**Consultation Response from Alan Smith,  
KC Waste Strategy( Refuse & Recycling)**

**2025/90517 land off, Forge Lane, Thornhill Lees, Dewsbury, WF12**

**Outline application, including the consideration of access and layout, for two commercial units  
(use class B2 and/or B8) and associated works**

**Date Responded: 04/07/2025**

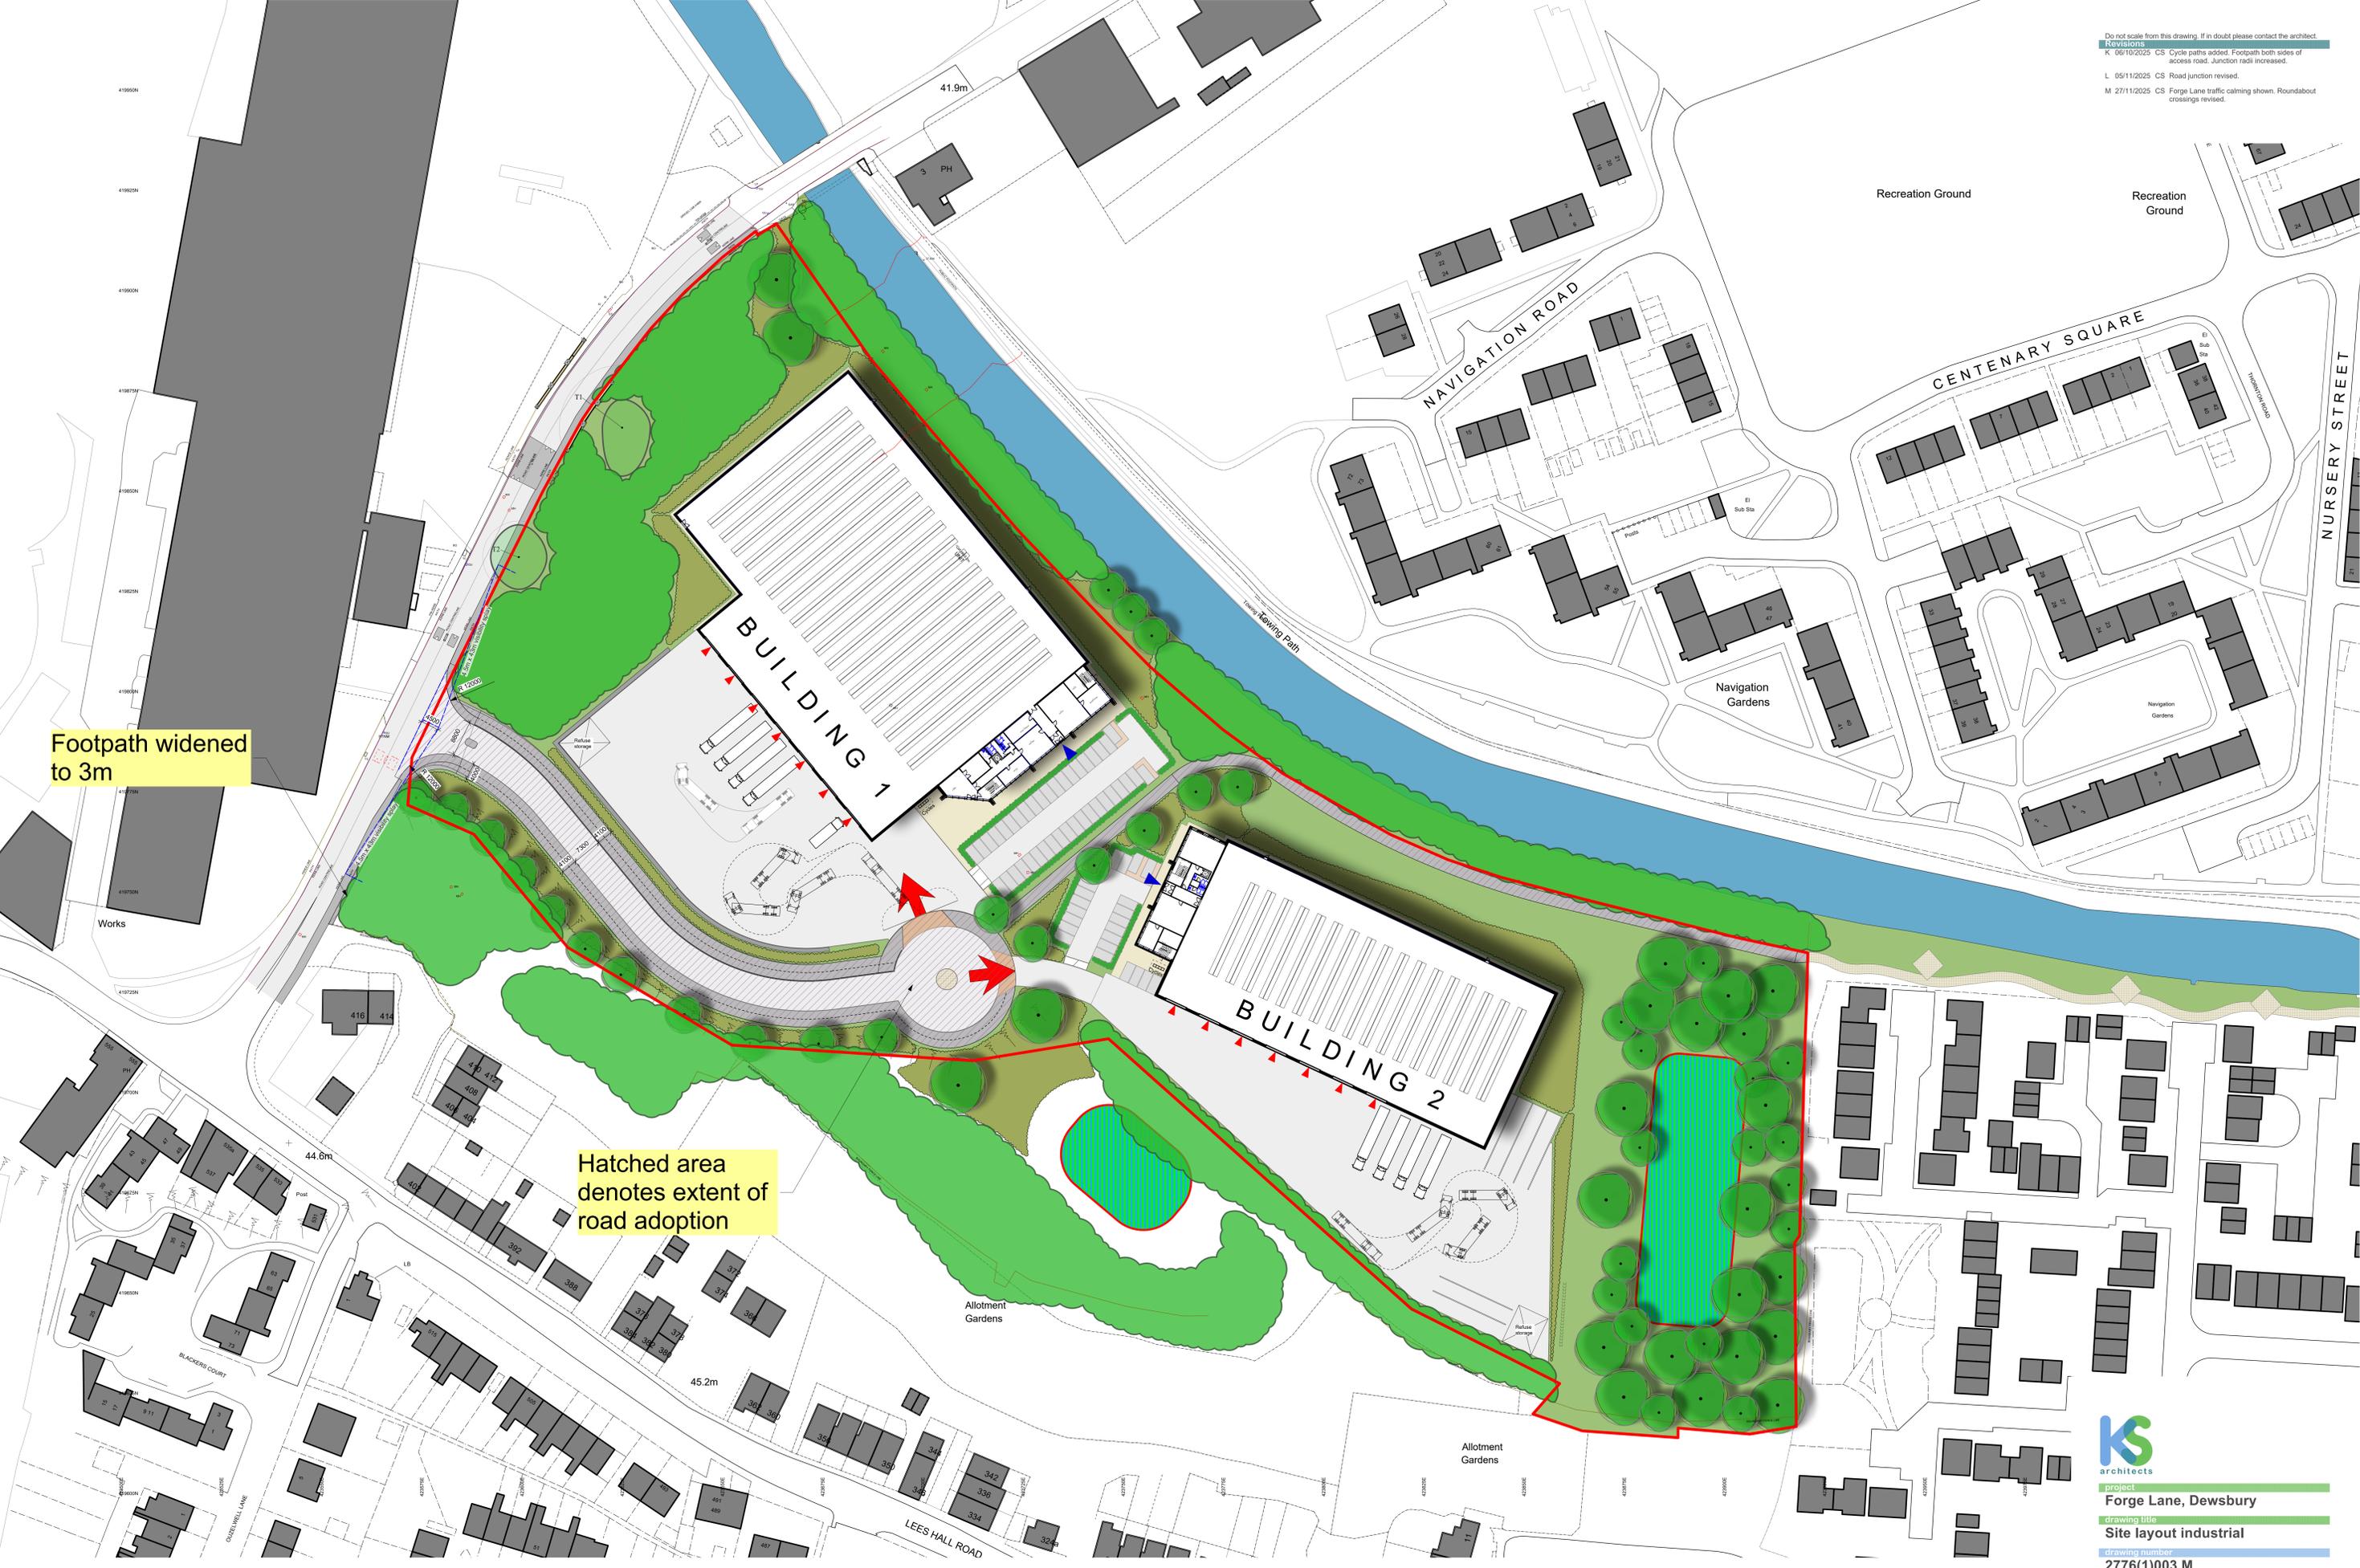
- *3.3 Identified with a cross is an area for the storage of bins etc. in the western corner of the car park for Building 1 and the same for Building 2 at the south eastern corner of its car park.*
- *3.4 Given the nature of the end users is not known at this stage, it is not known what particular requirements occupiers may have.*
- *3.5 Accordingly, the proposals at this stage are somewhat speculative.*
- *3.6 However it is fully intended that proposals will in due course be designed and submitted for planning approval to meet the requirements of the local plan policies identified.*

- Waste storage presents a fire risk and should be carefully considered when undertaking a fire risk assessment, If there is a waste storage compound external to the buildings it should be more than the 6m from properties as specified in guidance.

- If not using skips or FELs, the drag out distance for wheeled bins from a bin store / premises to the collection vehicle should preferably be under 15m. Access to and from the bin storage area should be constructed to withstand point loading and movement, impacts of larger bins over time, and to resist future rutting, pitting, cracking or other such surface degradation that would impair bin manoeuvring

- In compliance with the waste hierarchy the WCA would encourage reuse or recycling of demolition materials within the construction project.
- With regards to the office waste, clarification is required on how this waste will be managed, stored and where it will be collected from.

- Where turning is necessary, the turning facilities must be demonstrably sufficient for a refuse collection vehicle. Swept path analysis must show the manoeuvrability of this vehicle throughout the site, demonstrating the safe passing of other vehicles likely to be using the access – either parked or moving.

- A. Before development commences, further details to ensure suitable storage, and access for collection of wastes from the buildings shall be submitted to and approved in writing by the Local Planning Authority. The approved details shall be provided before first occupation and shall be so retained thereafter.
- B. Before development commences, details of the management and maintenance of communal refuse storage areas by a designated private management company shall be submitted to and approved by the Local Planning Authority. The approved details shall be provided before first occupation and shall be so retained thereafter
